BCA ASSESSMENT REPORT

**Yiribana Logistics Estate, Kemps Creek
Warehouse 1 & 3 (Stage 1)**

**Prepared For:
The GPT Group**

Date: 28 May 2021

01 WH1 GROUND FLOOR OFFICE PLAN 1:200

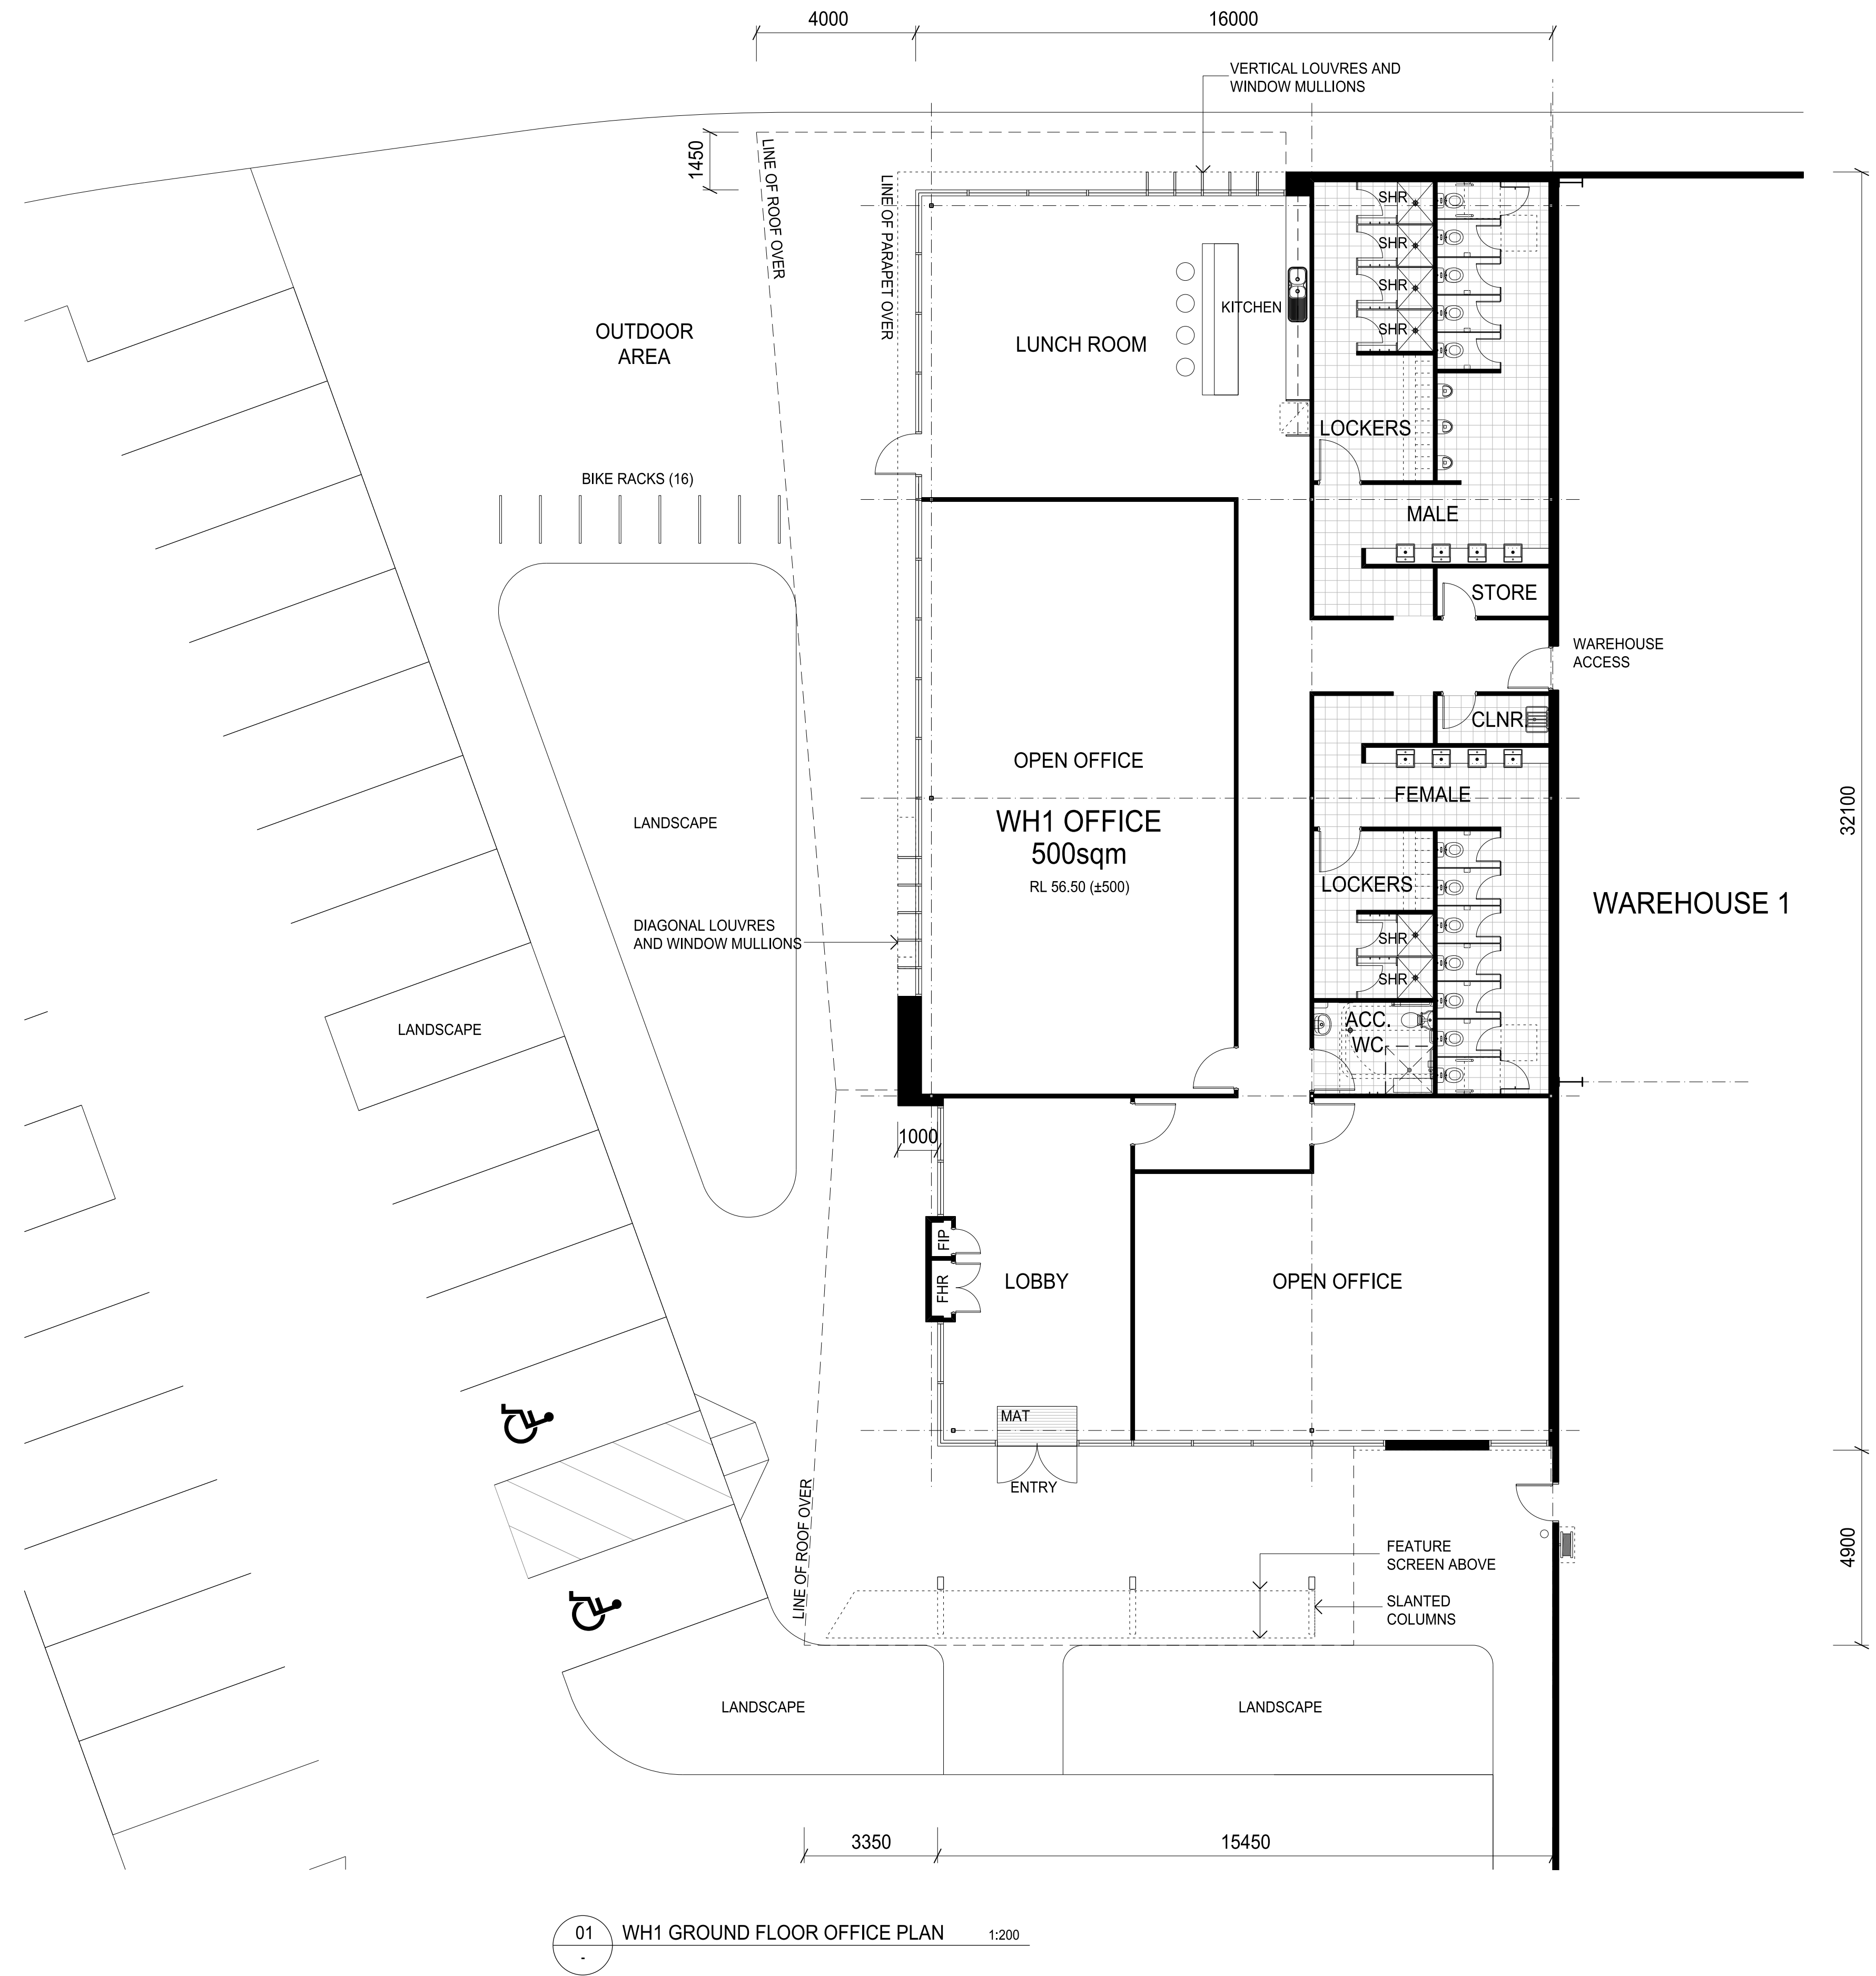
Comments: The proposed Warehouse buildings do not comply with the provisions of C2.4 and thus the following non-compliance issues are required to be addressed as a Performance Solution by the Fire Engineer to demonstrate compliance with Performance Requirement CP9:

Warehouse 1

- + *Perimeter Vehicular Access is greater than 18m from the external walls along the western side of the building, along the southern side of the warehouse at the recessed docks and in the south-eastern corner near the sprinkler tank & pump room – refer below mark-up:*

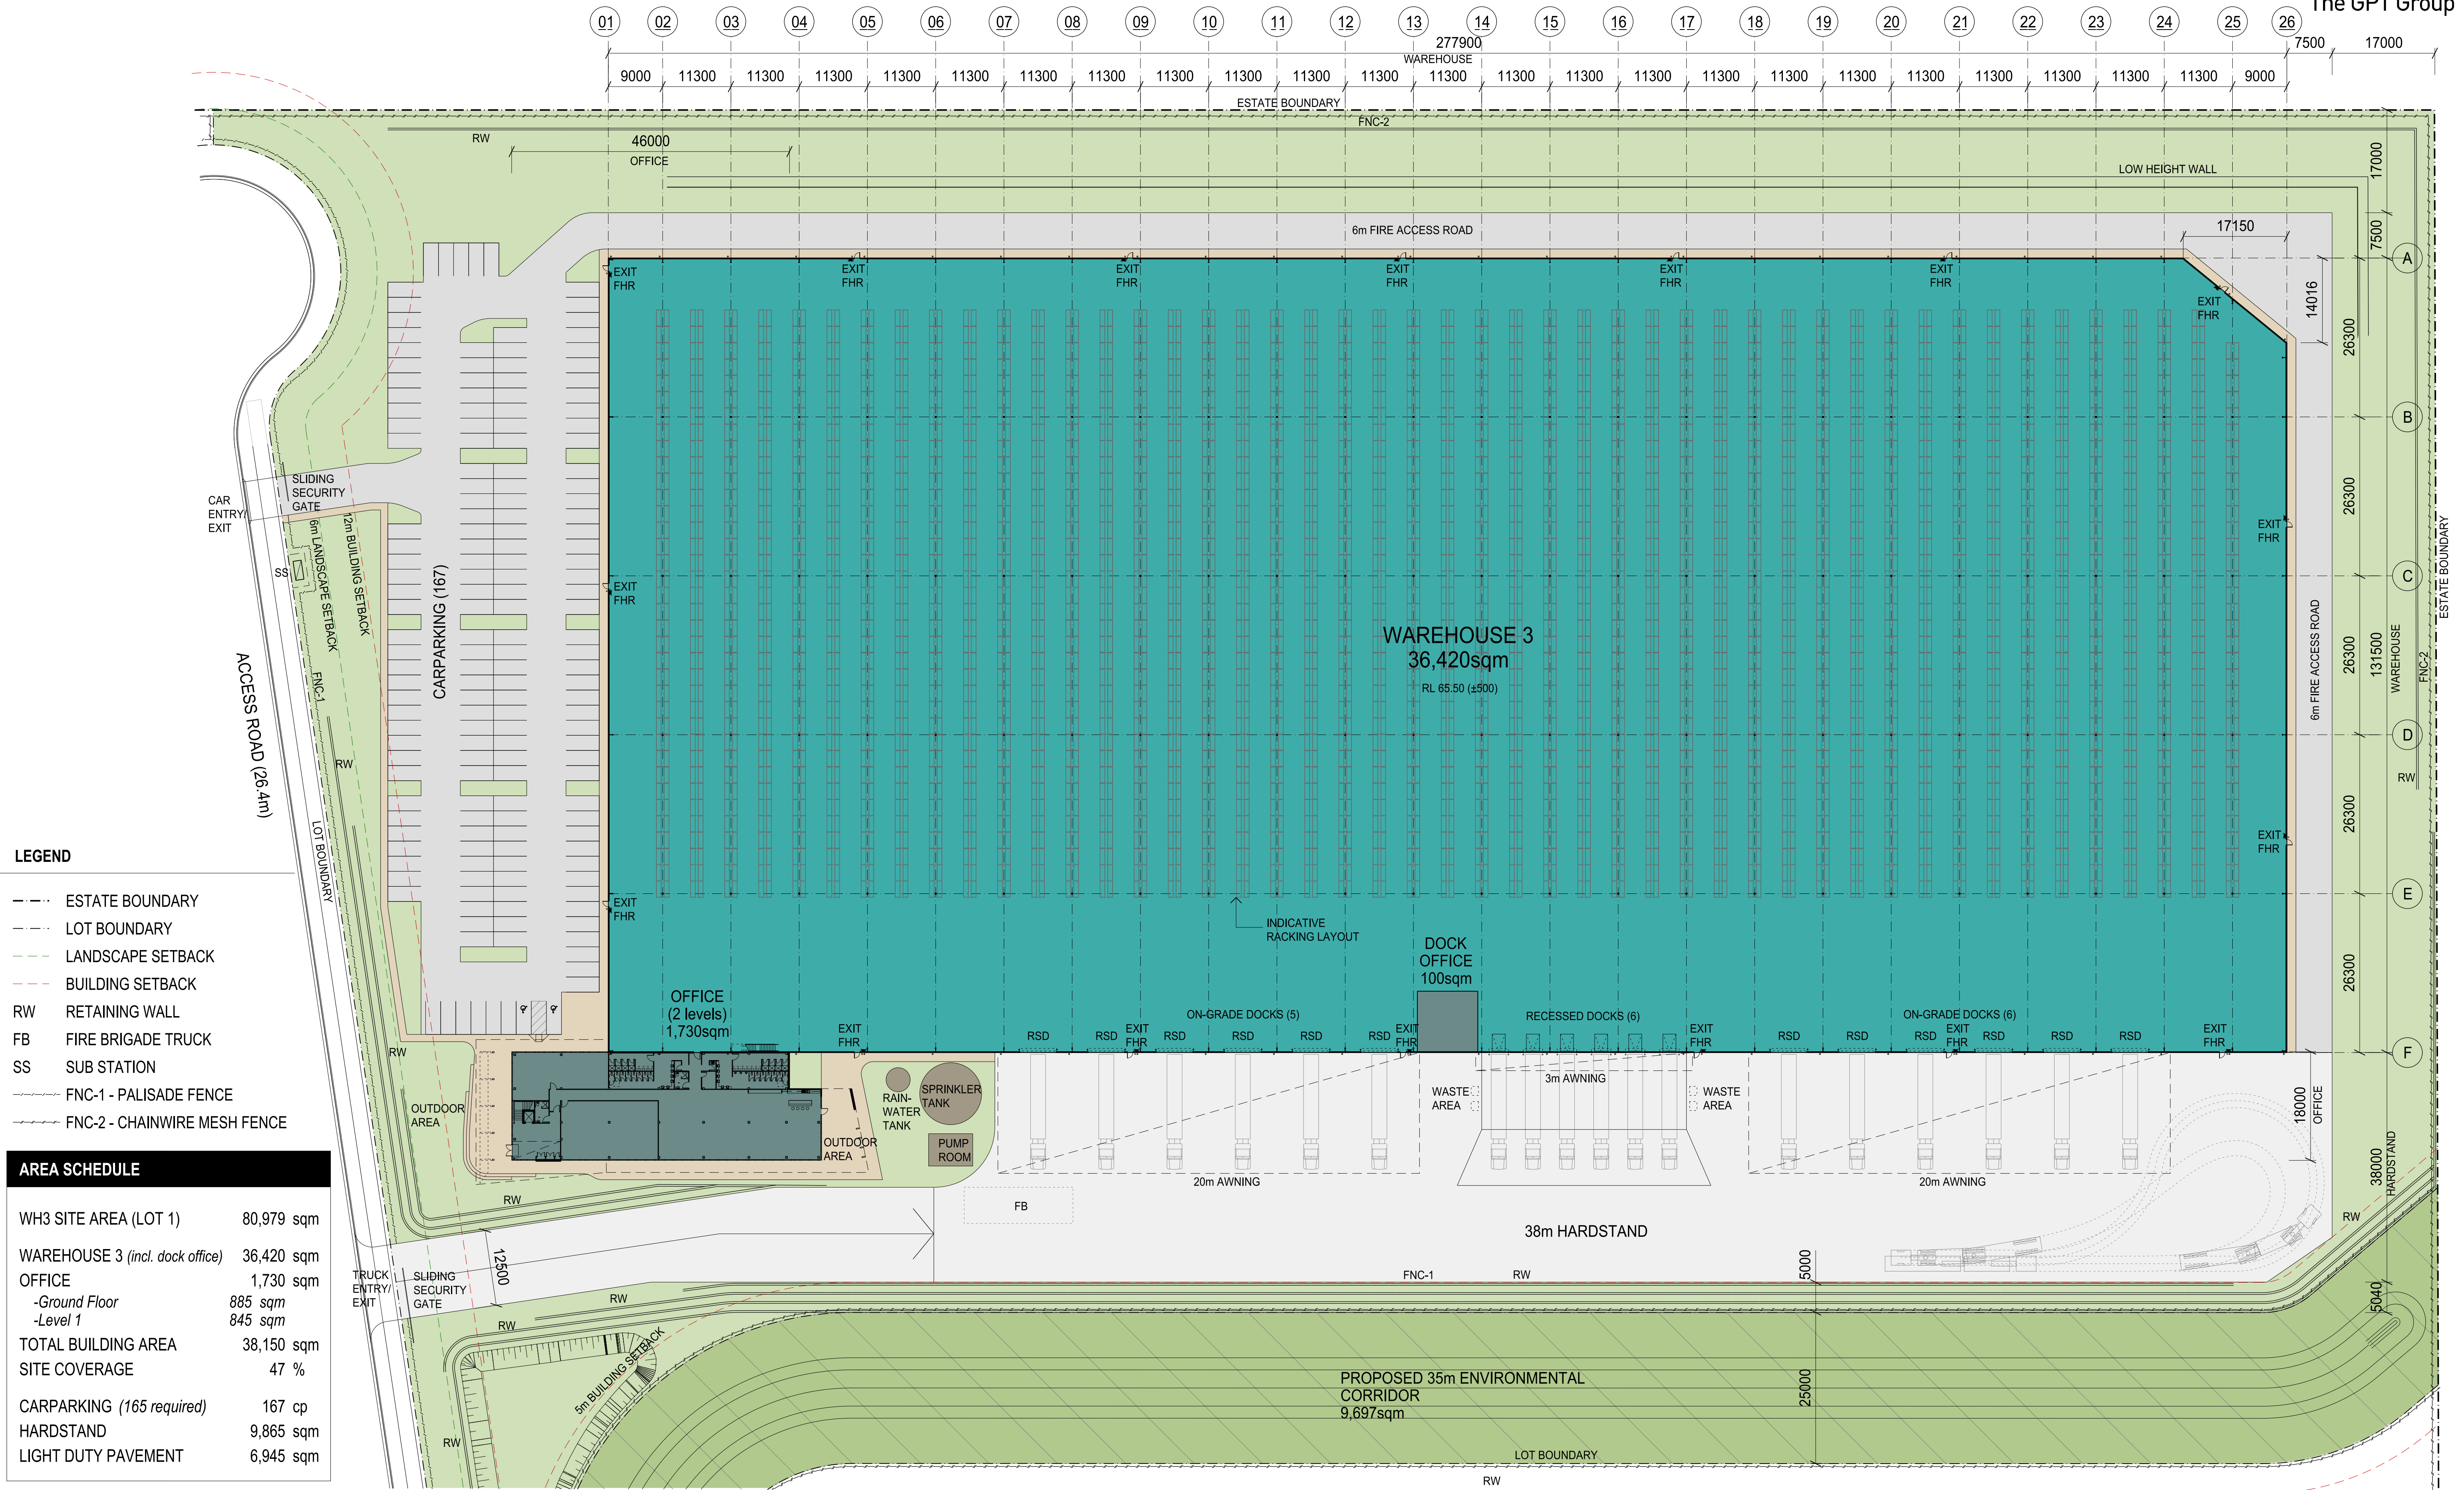
Warehouse 3

- + *Perimeter Vehicular Access is greater than 18m from the external walls along the western side of the building, along the southern side of the warehouse at the recessed docks and near the sprinkler tank & pump room – refer below mark-up:*
